**KIRKLEES METROPOLITAN COUNCIL
INVESTMENT & REGENERATION SERVICE**

**DELEGATED DECISION FOR DISCHARGE OF CONDITION -
NOTIFICATION OF TELECOMMUNICATIONS DEVELOPMENT**

Reference no. 2023/N /91704/W

**Site Address Almondbury Cricket Club, Fernside
Avenue, Almondbury, Huddersfield**

Title: **002 SITE LOCATION PLAN**

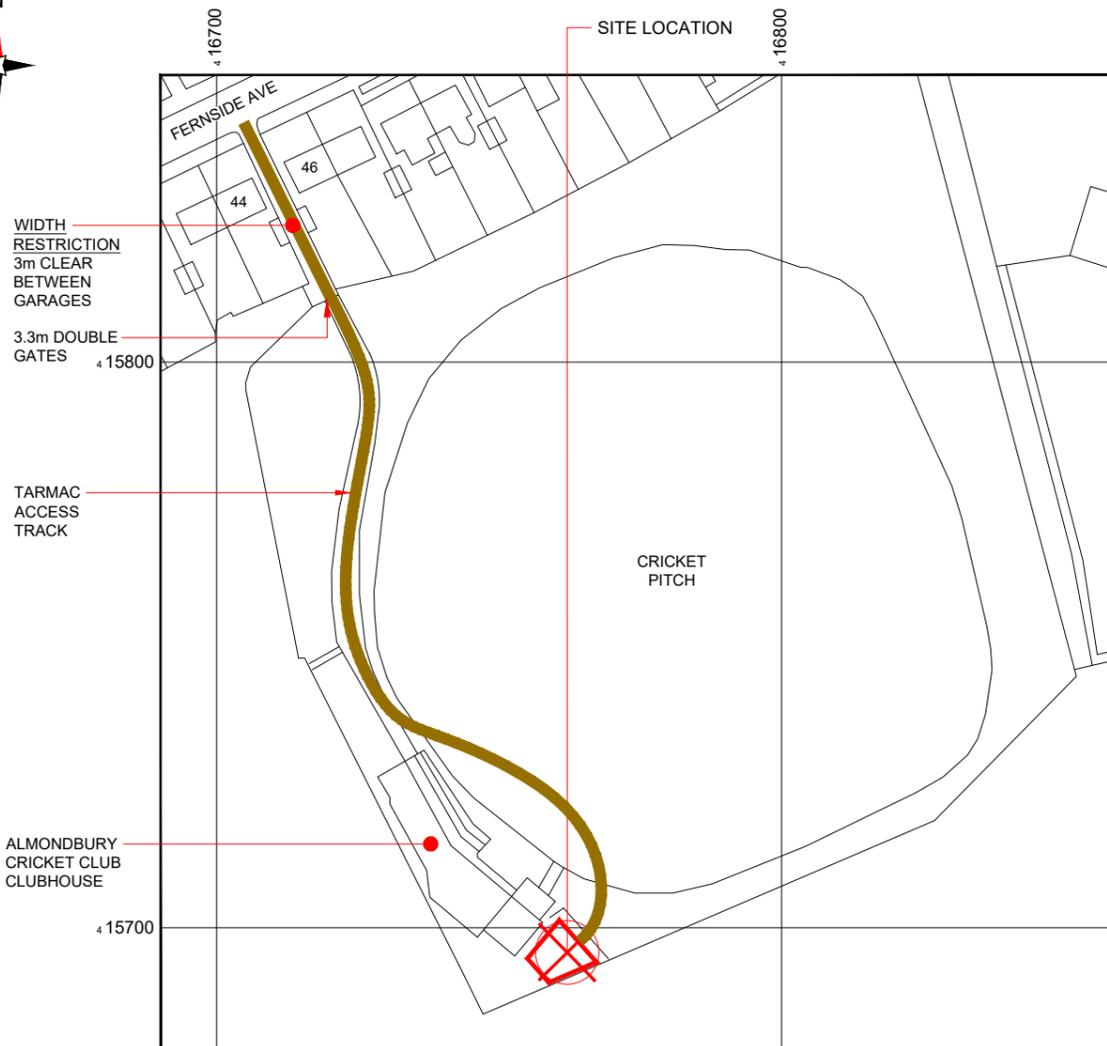
4.1 24-Jul-2023: Amended plan showing that there would be no permanent new access road. This was not re-publicised as it was for purposes of clarification only.

- 9.19 The Lease Demise plan (now superseded) appeared to show a new tarmac access track cutting across a corner of the cricket pitch. This would have meant a loss of functional urban green space and would therefore have been unacceptable without further justification. The latest plan, 1700355_KKS251_96739_M001 Revision A, shows that the access track across the pitch will be a temporary measure to allow access during construction. There will therefore be no permanent or long-term loss of any playing facilities.
